KITTTITAS COUNTY COMMUNITY DEVELOPMENT SERVICES

August 13, 2025

RE: Shoreline Exemption Permit (SX-25-00012 Johnson) – Deemed Incomplete – Request for Additional Information

OSS SITE PLAN

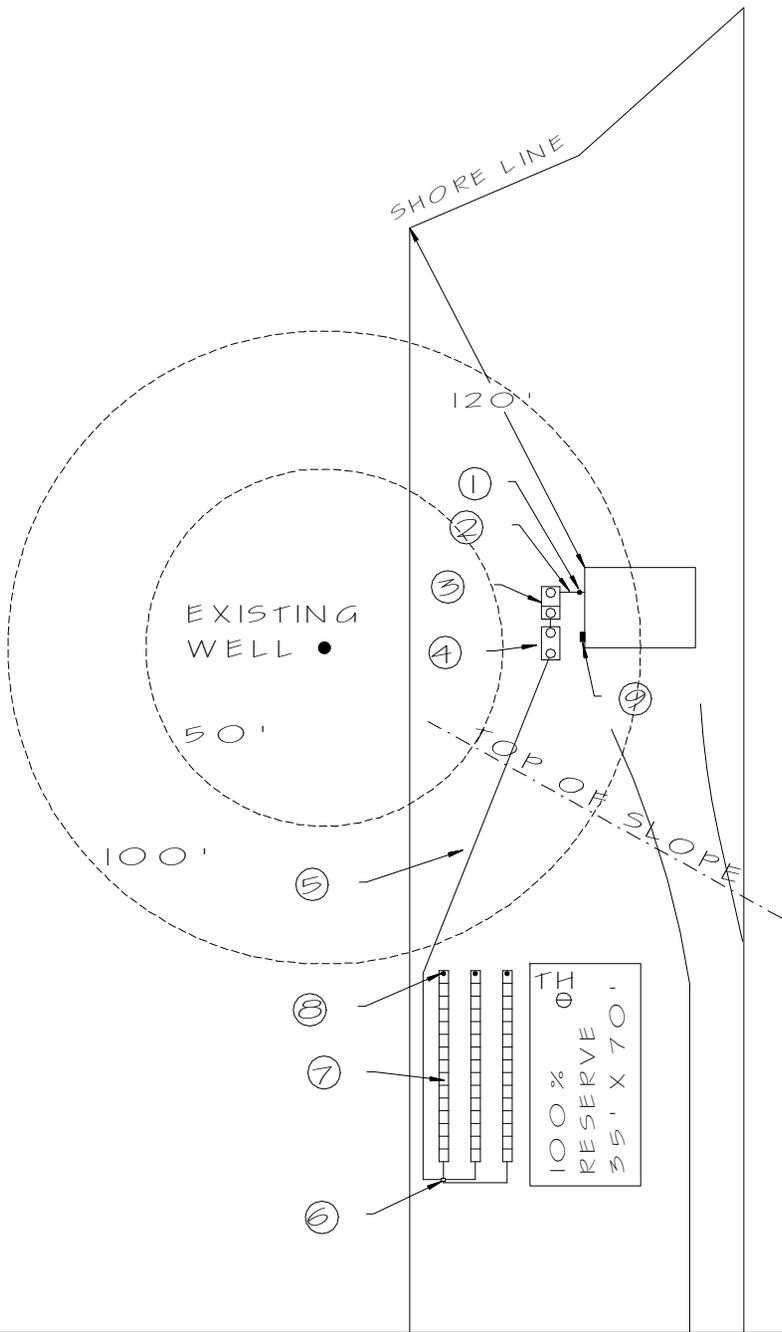
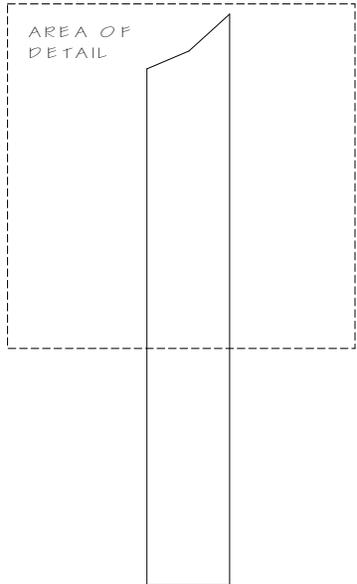
1. Please provide an updated site plan showing the exact location of all proposed structures, septic system components, drain fields, etc. In addition, please provide their dimensions, as well as each component's distances from property lines, rivers, and horizontal distances from the Ordinary High Water Mark (OHWM).

- a. The site plan submitted with your On-Site Sewage System (OSS) application does not match the site plan provided with your shoreline exemption application. For CDS to process the shoreline exemption correctly, both applications must reference the same, consistent site plan.

- b. At this time, the site plan submitted for the OSS permit indicates that the septic tanks are located within the 115-foot shoreline buffer, which is not permissible. Septic tanks must be located outside of this buffer. However, the proposed location of the drain fields is acceptable.

- c. Please submit a revised site plan that accurately depicts the location of both the septic tanks and the drain fields. If the site plan previously submitted to Public Health reflects the correct locations, kindly forward that version to CDS. If there have been any changes to the locations, an updated site plan must also be submitted to Public Health.
